**Application for a non-material amendment following a grant of planning permission,  
Town and Country Planning Act 1990**

**Non Material Amendment on previous application 2016/91501 for erection of first  
floor side and rear extension, single storey rear extension and vehicular entrance  
gates (within a Conservation Area)**

**Braystone House, 32a, Wilshaw Road, Meltham, Holmfirth, HD9 4DZ**

**Application Number: 2016/93021**

site layout plan - 1:200

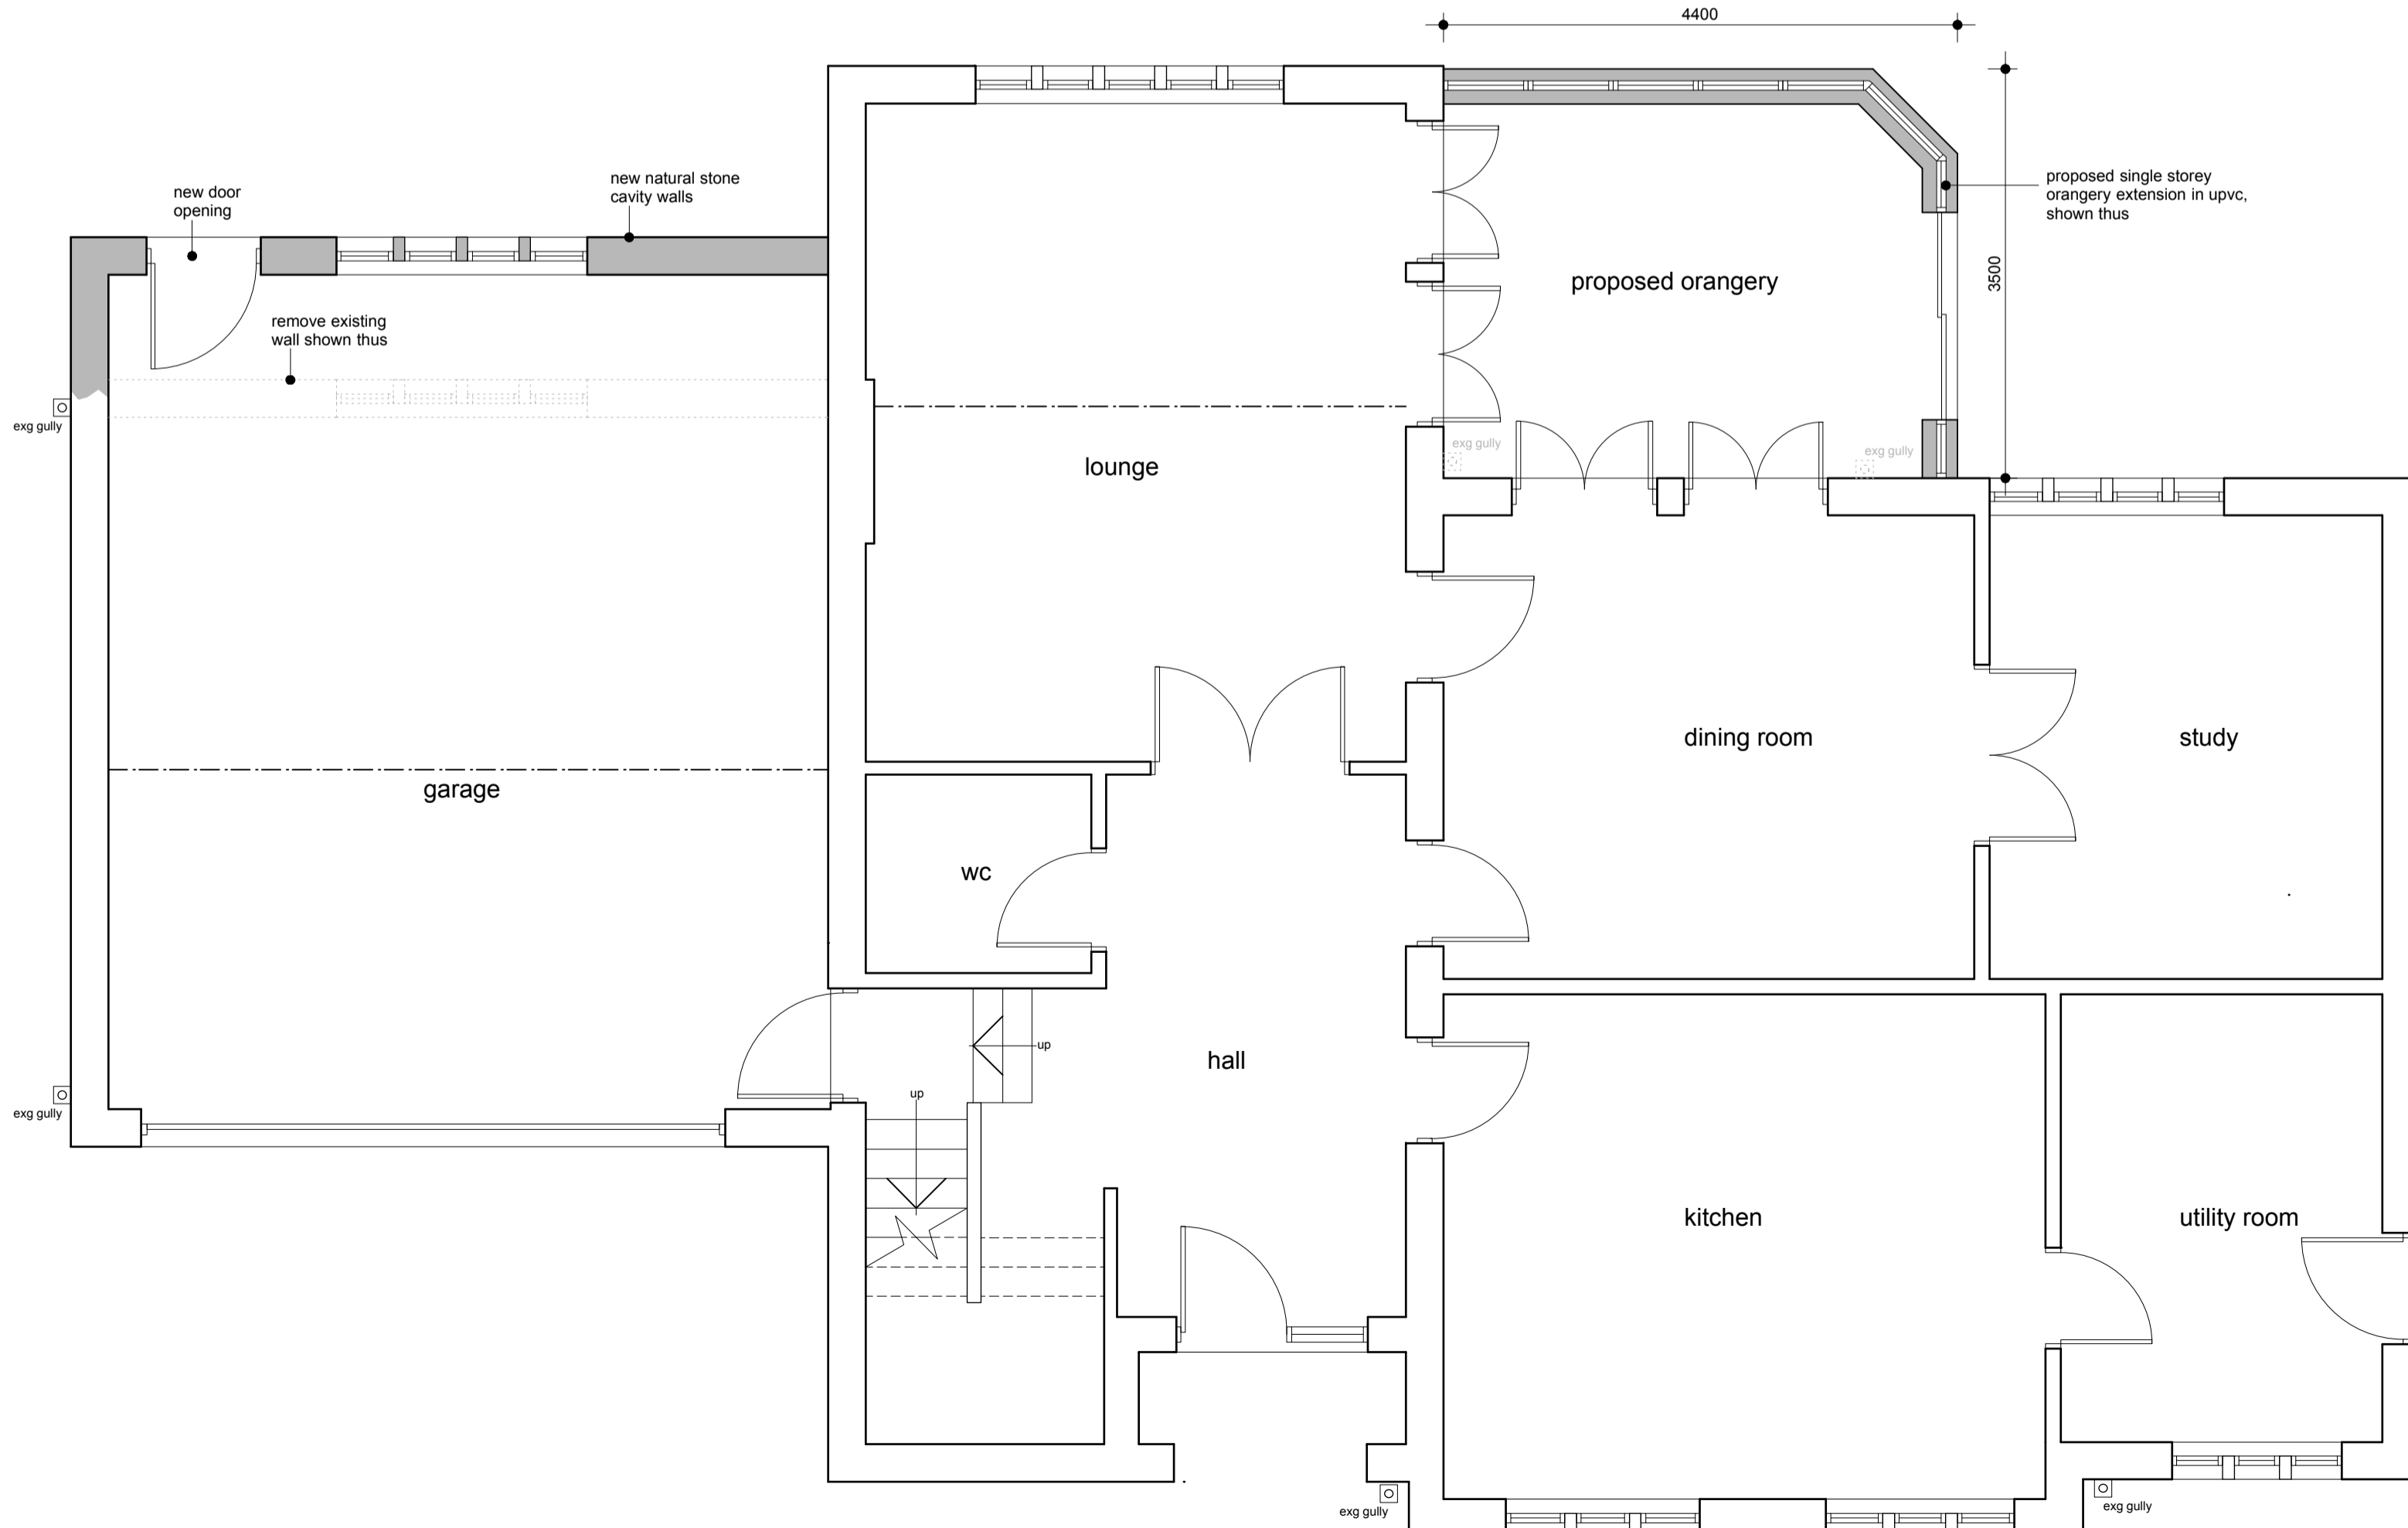
- Brick up the gaps in the ground floor support walls of the previously approved first floor side extension and erect a window and a door to enlarge the existing garage.
- Enlarge the previously approved rooflights.

These amendments are as indicated on drawing no's 16026D-01-P05 titled "plans, location & site plan as proposed" and drawing no. 16026D-02-P06 titled "elevations as proposed" received by the Local Planning Authority on 08 September 2016.

I confirm that the alterations are acceptable and may be considered as a non-material amendment to the approved drawings. It should be noted that this letter relates only to the non-material amendment sought and it is not a re-issue of the original planning permission. The two documents should be read together and as such, all conditions imposed on the original granting of planning permission apply to the proposal as now amended. A copy of this letter and the amended plans will be retained on the public record of approved documents.
